**OUFC Planning Application Ref: 24/00539/F**

## **Proposed Transport Strategy**

### **From: Friends of Stratfield Brake (FoSB)**

**This is an objection to the applicant's proposed transport strategy. Transport is a key area of concern for us.**

Figure 4.1: OUFC VISSIM Model Extents

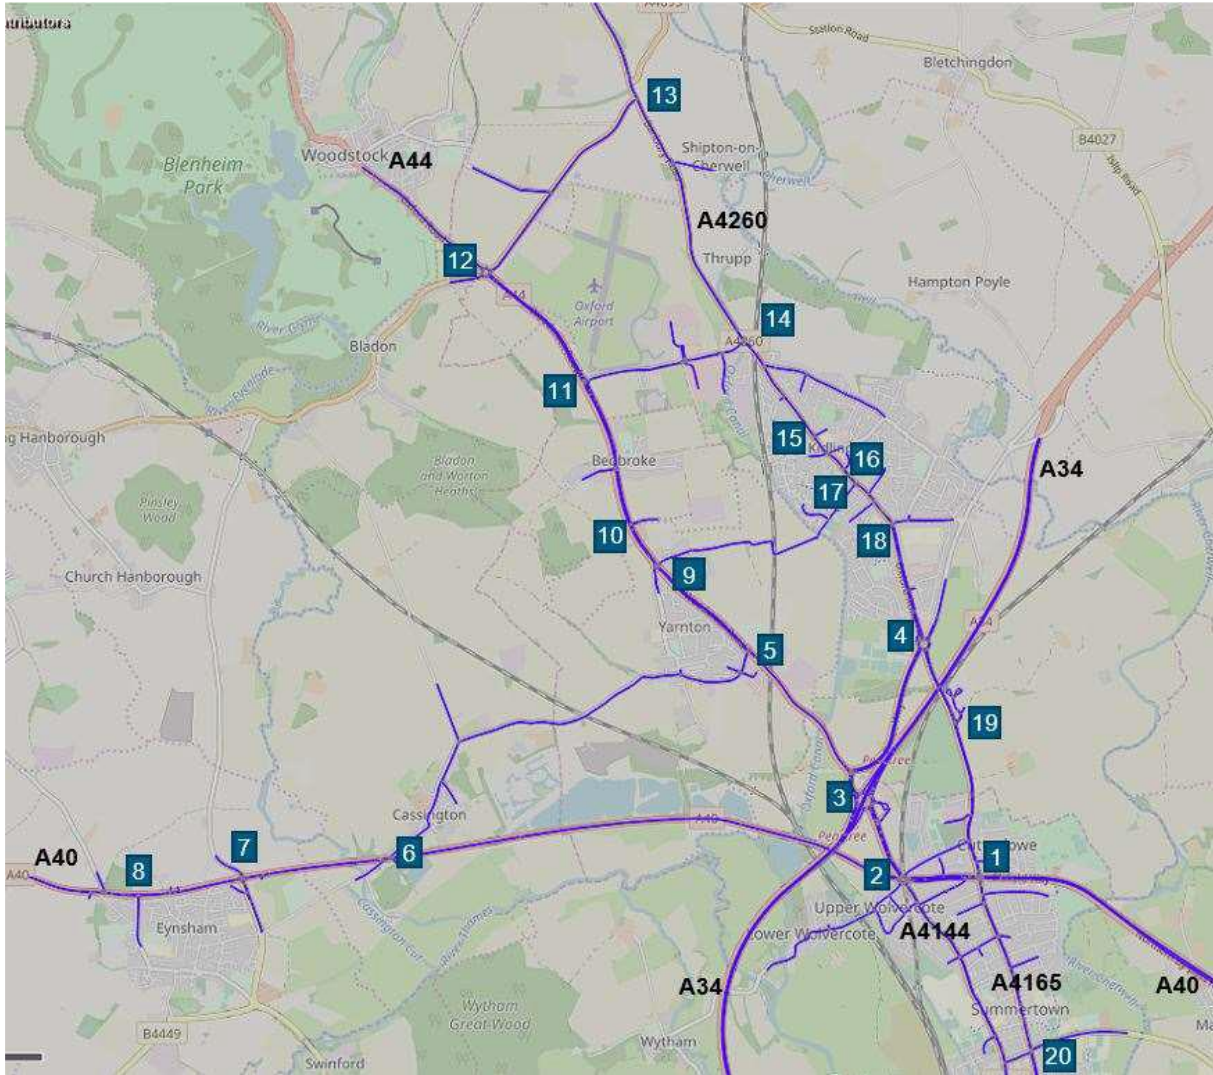
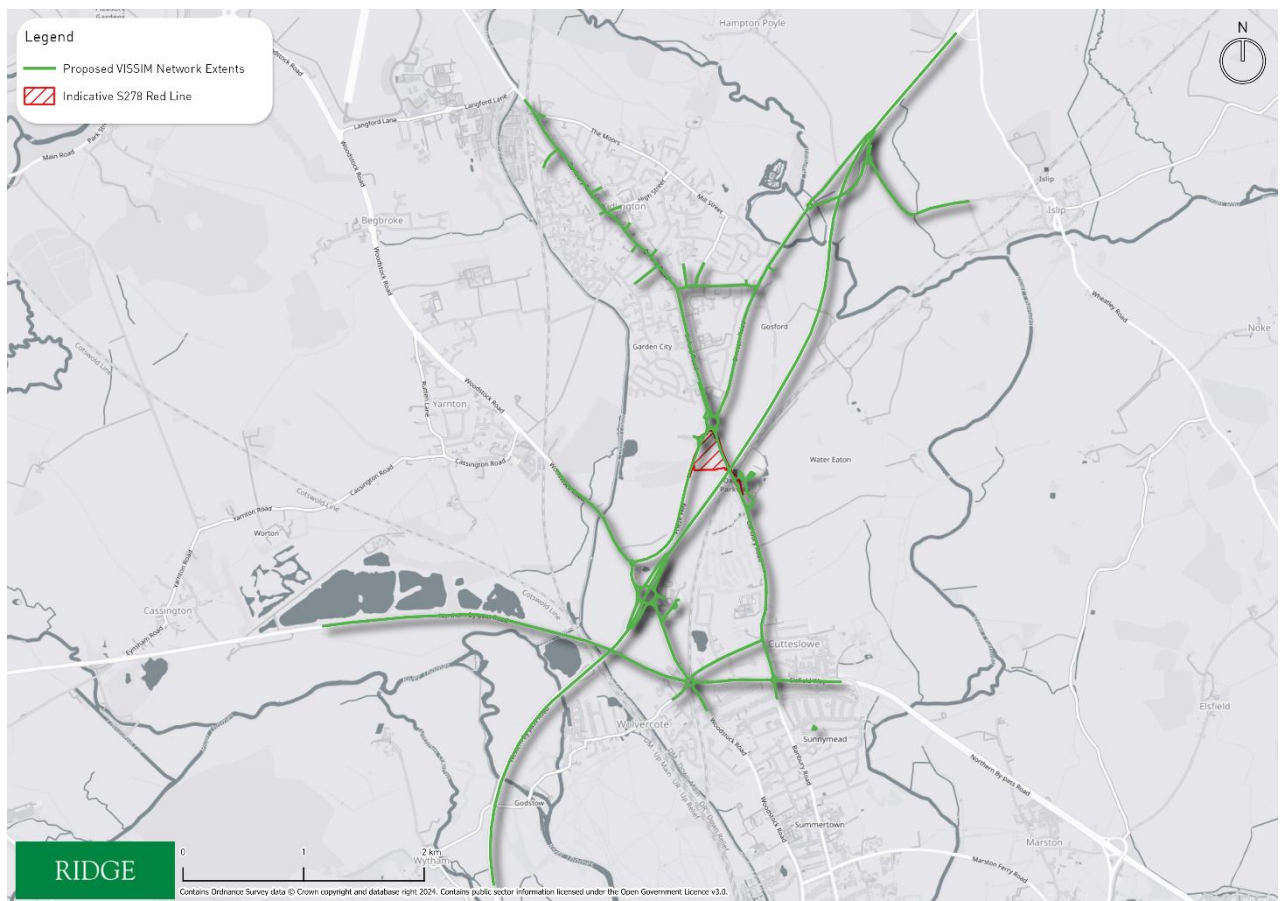
- We note that traffic modelling using the VISSIM model is still in progress and that this will be the subject of further consultation when the results are available.

- The traffic modelling must take account of the substantial development already committed in the area, both commercial and residential. It should also take account of the planned closure of Sandy Lane.

TITLE:  
**GENERAL ARRANGEMENT  
PART 3 OF 4**

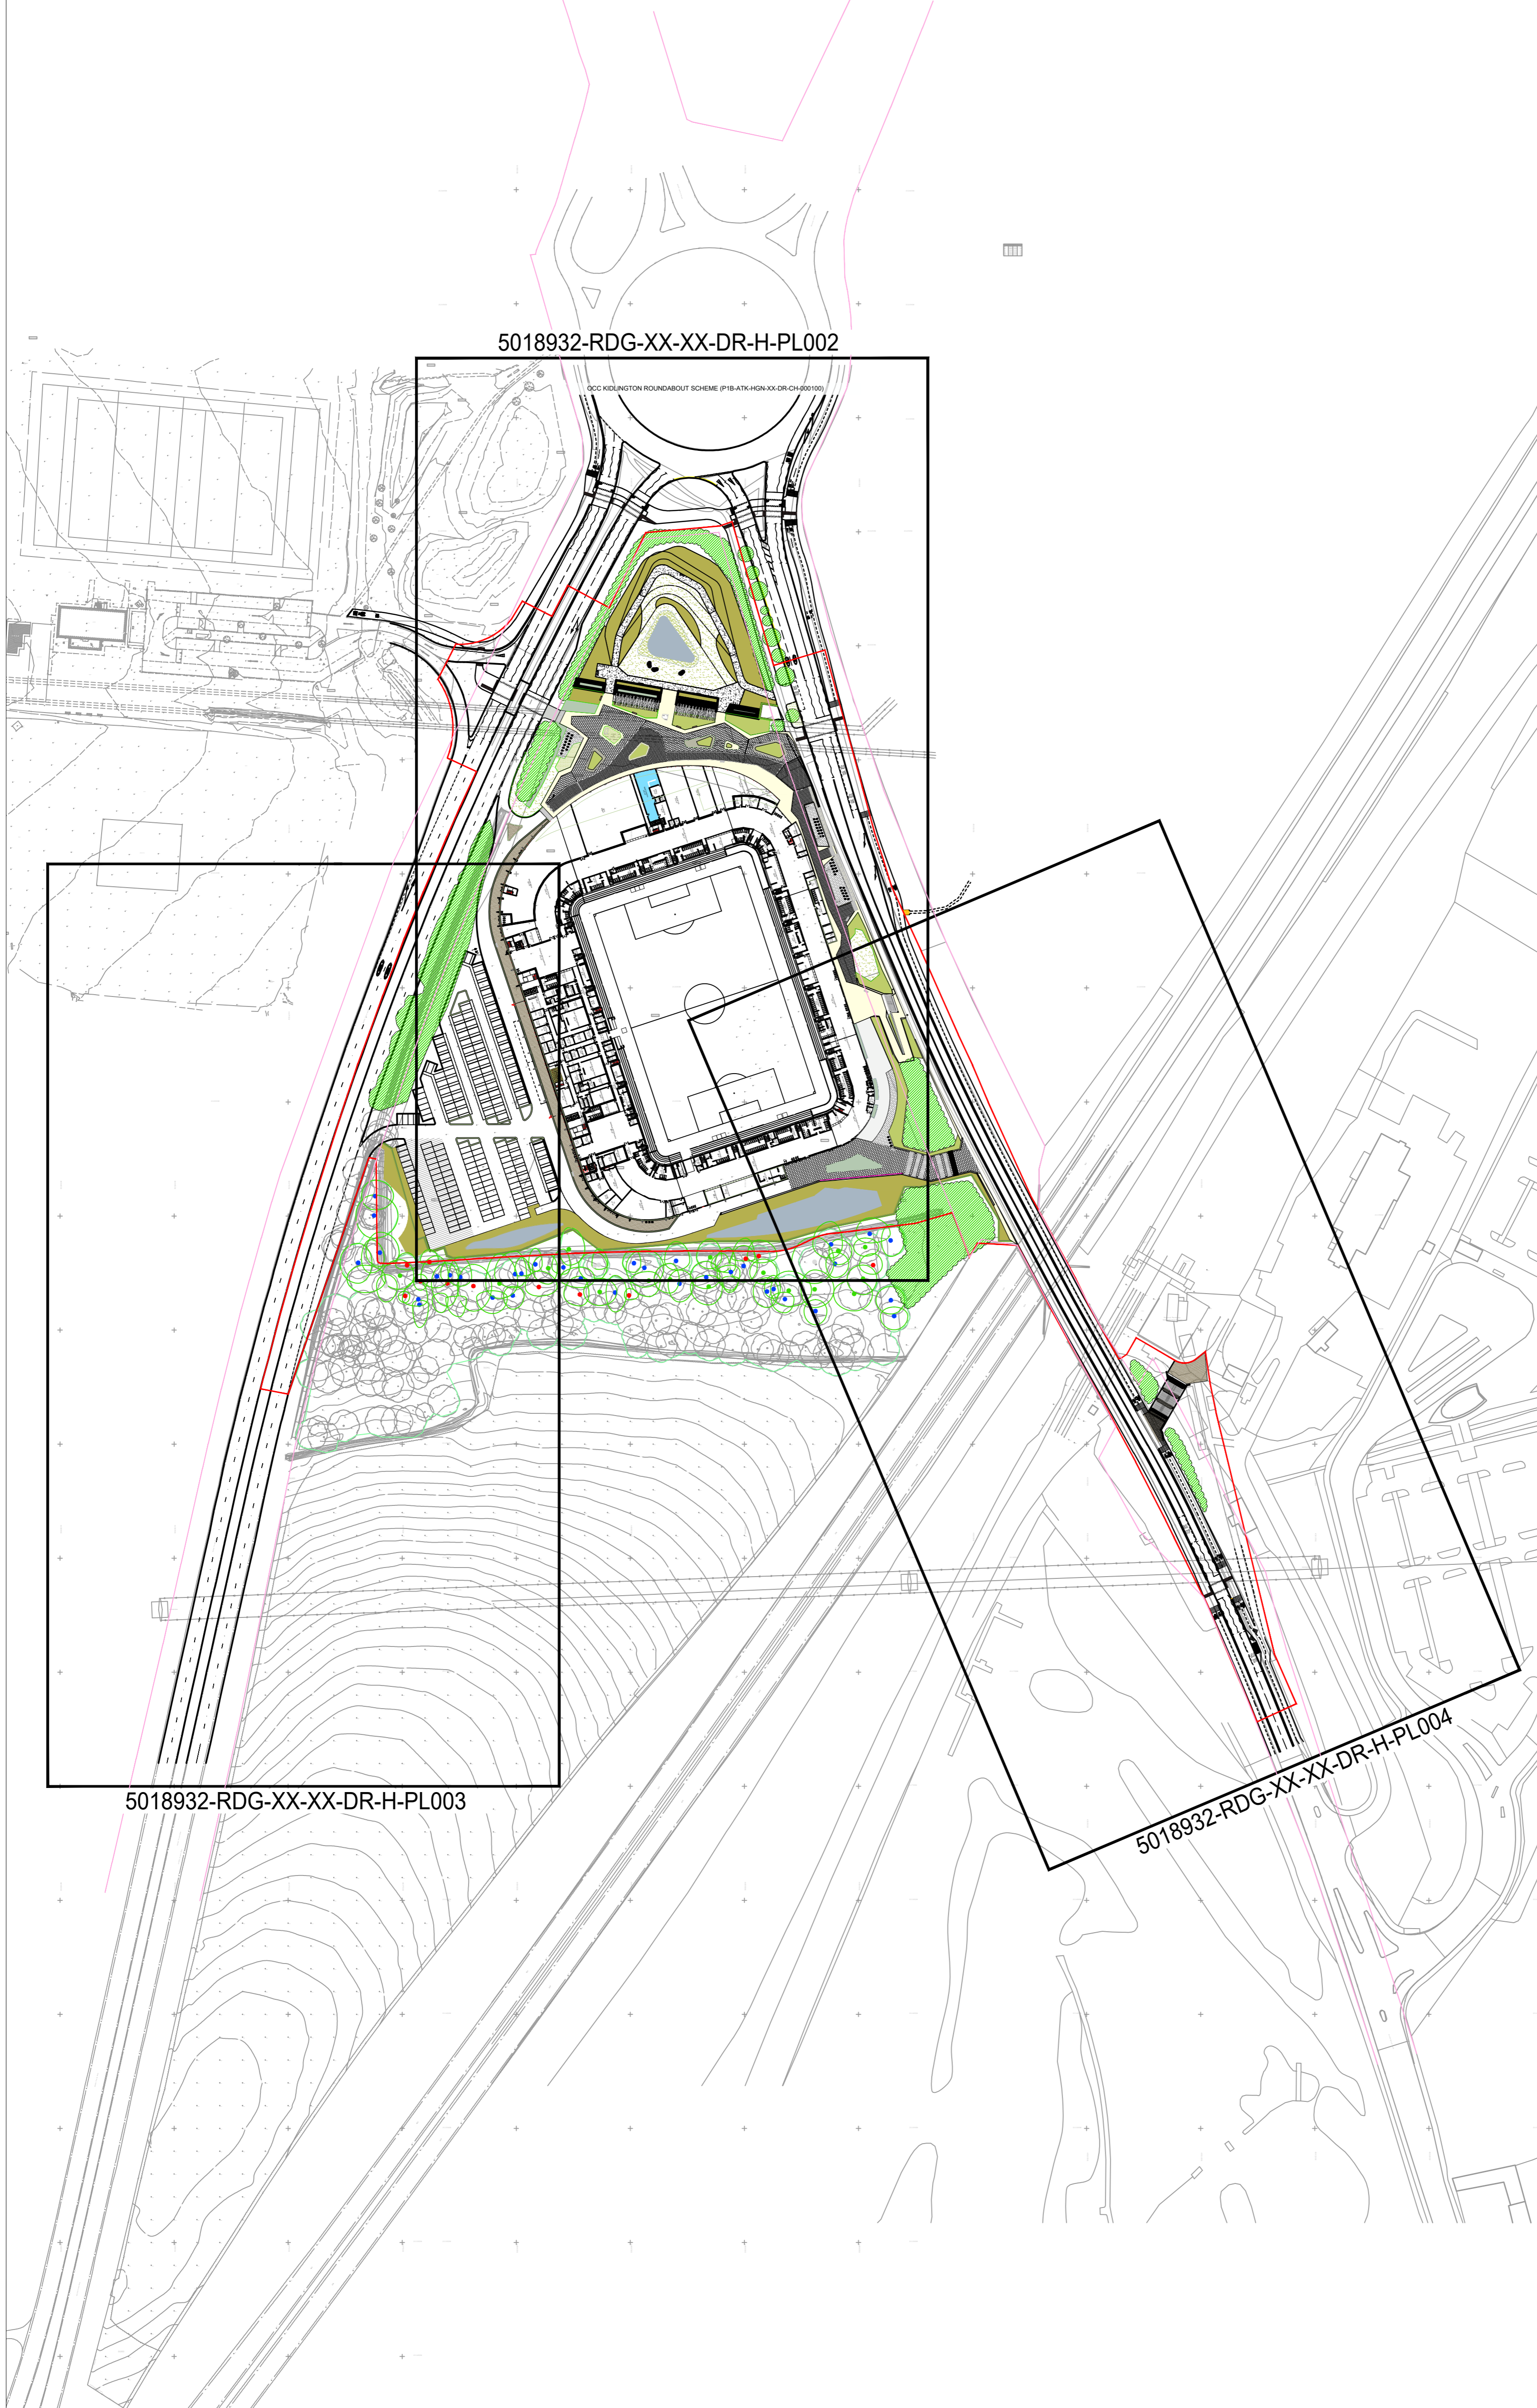
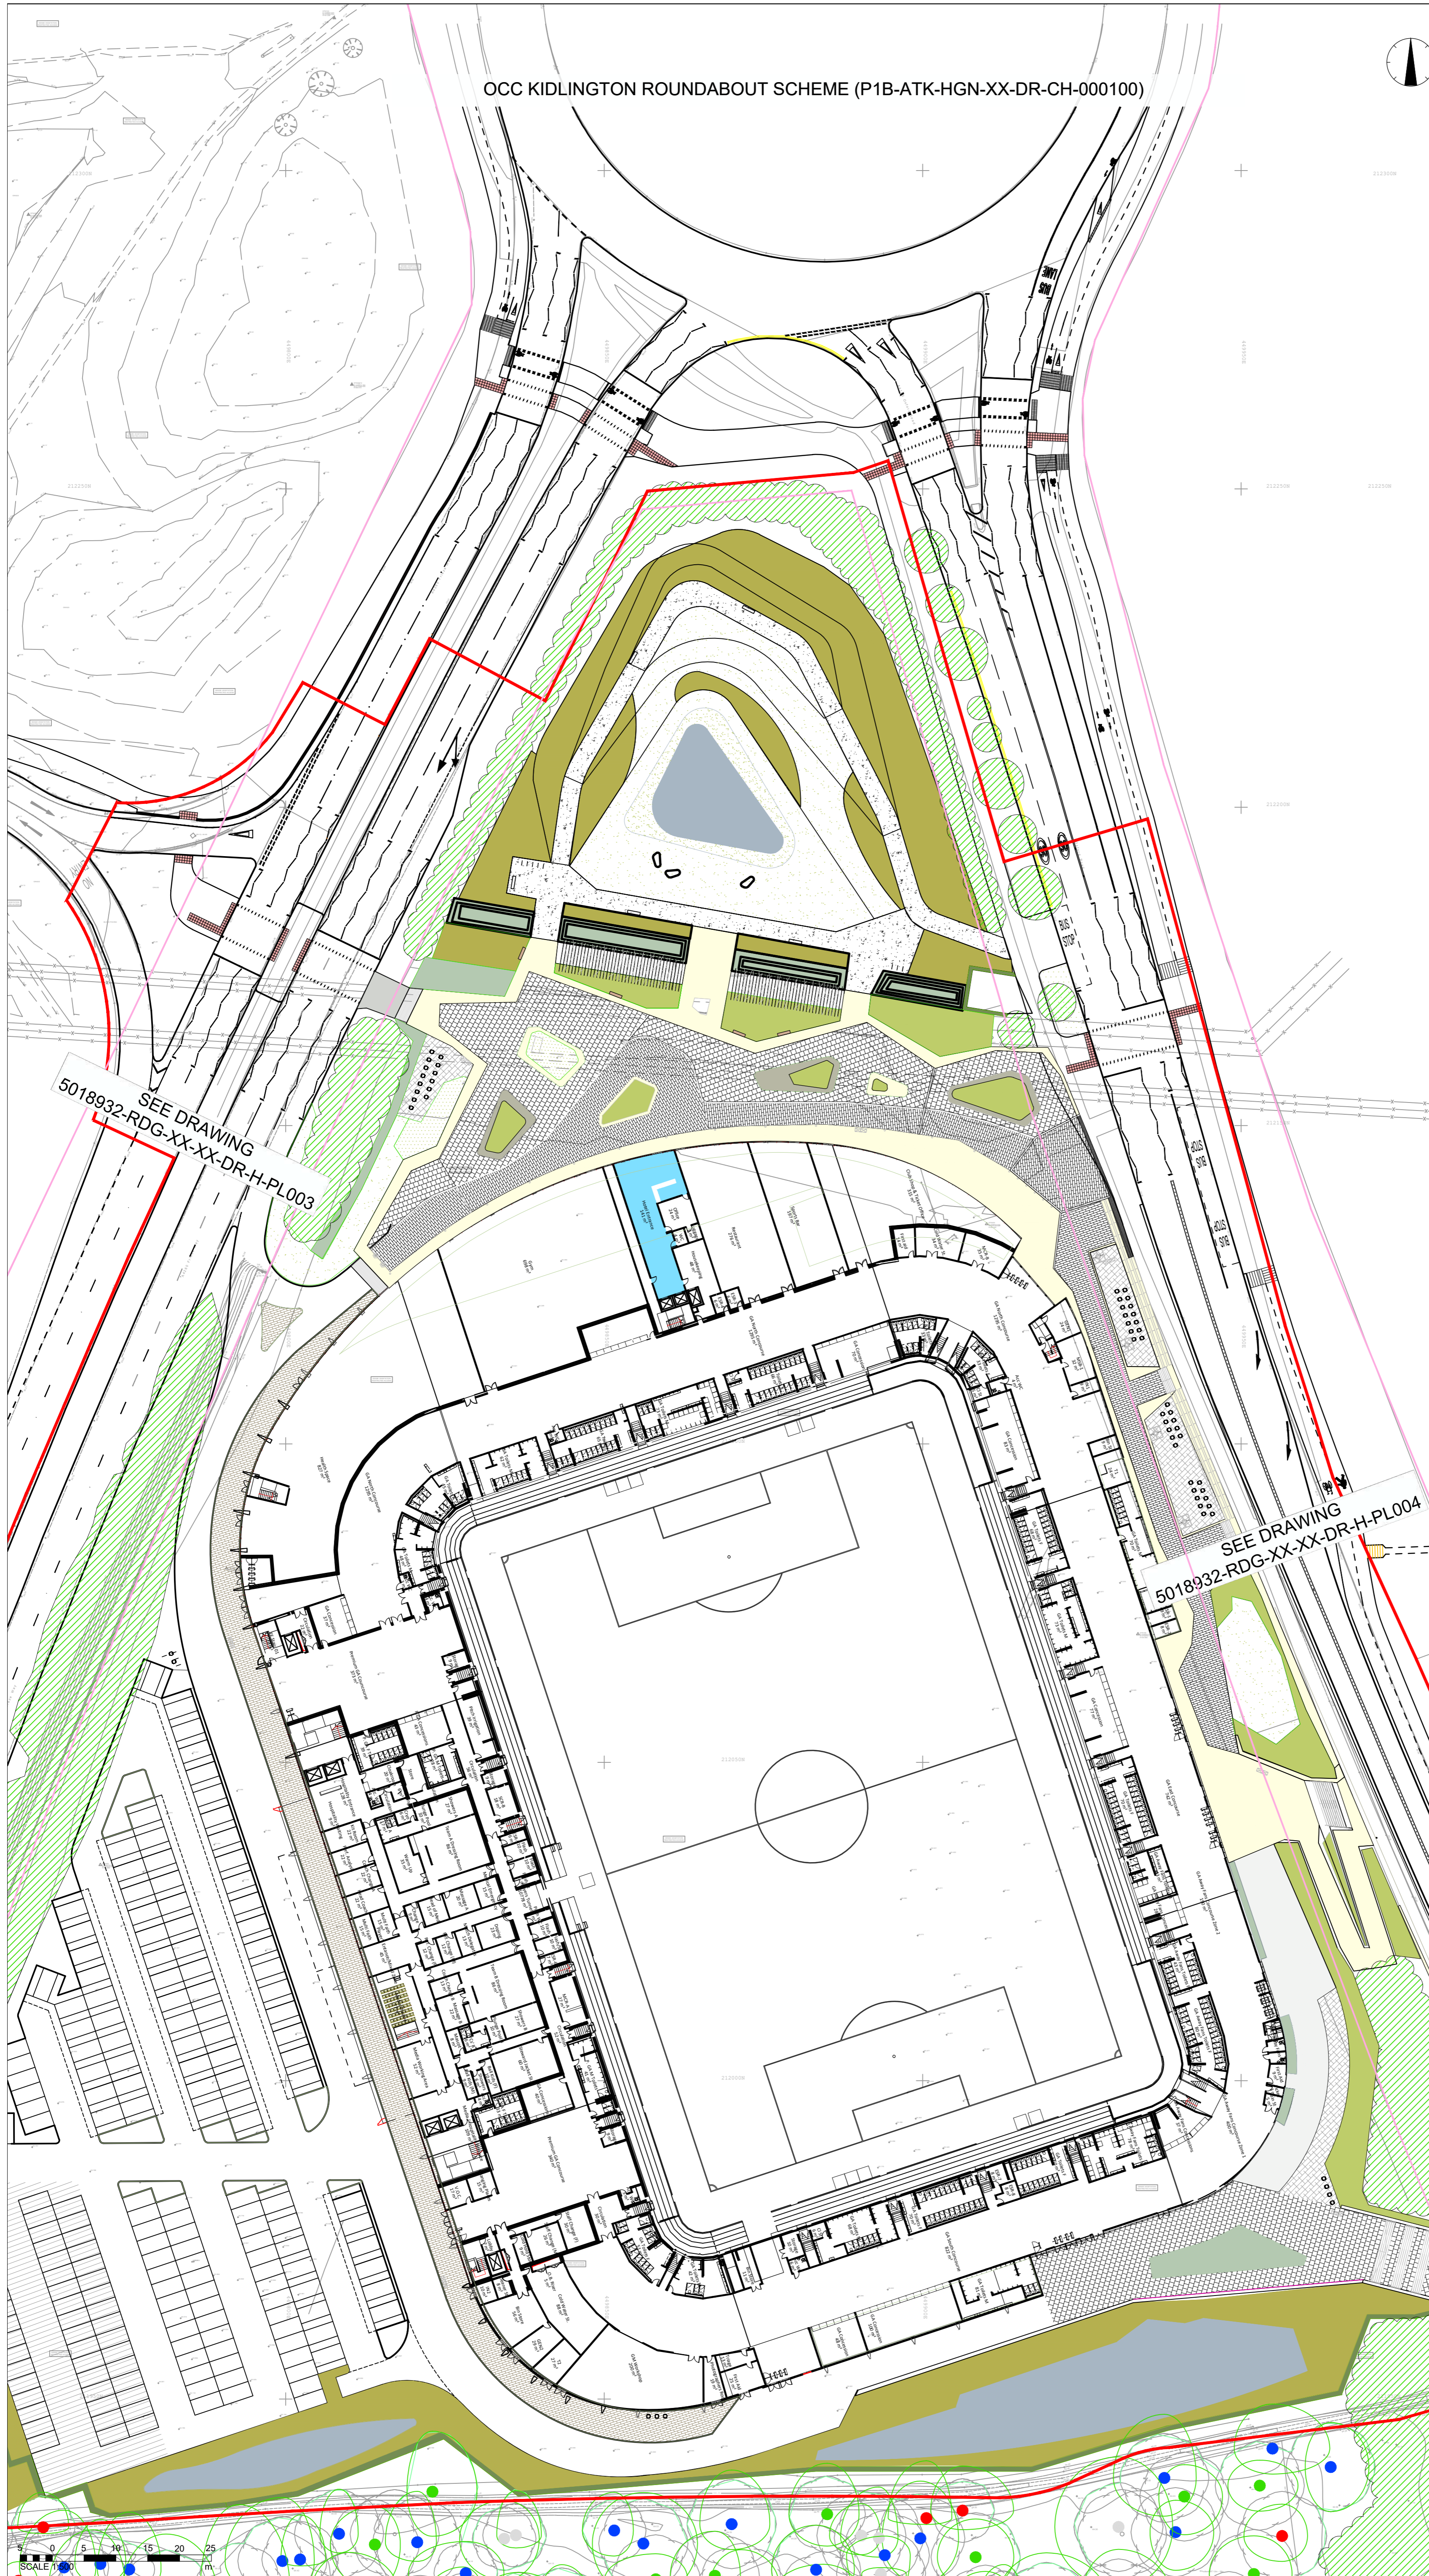
- The bus lane southbound from the Kidlington Roundabout to Oxford Parkway has been removed in the stadium plans. This is another anti-bus measure that will lead to delays for buses and therefore passengers. People who use public transport to commute using this route should not be disadvantaged by the removal of a bus lane.

- The 3m pathway plus .5m buffer zone on Frieze Way (as required by OCC) would appear to mean further loss of vegetation and biodiversity and will affect the BNG metric.
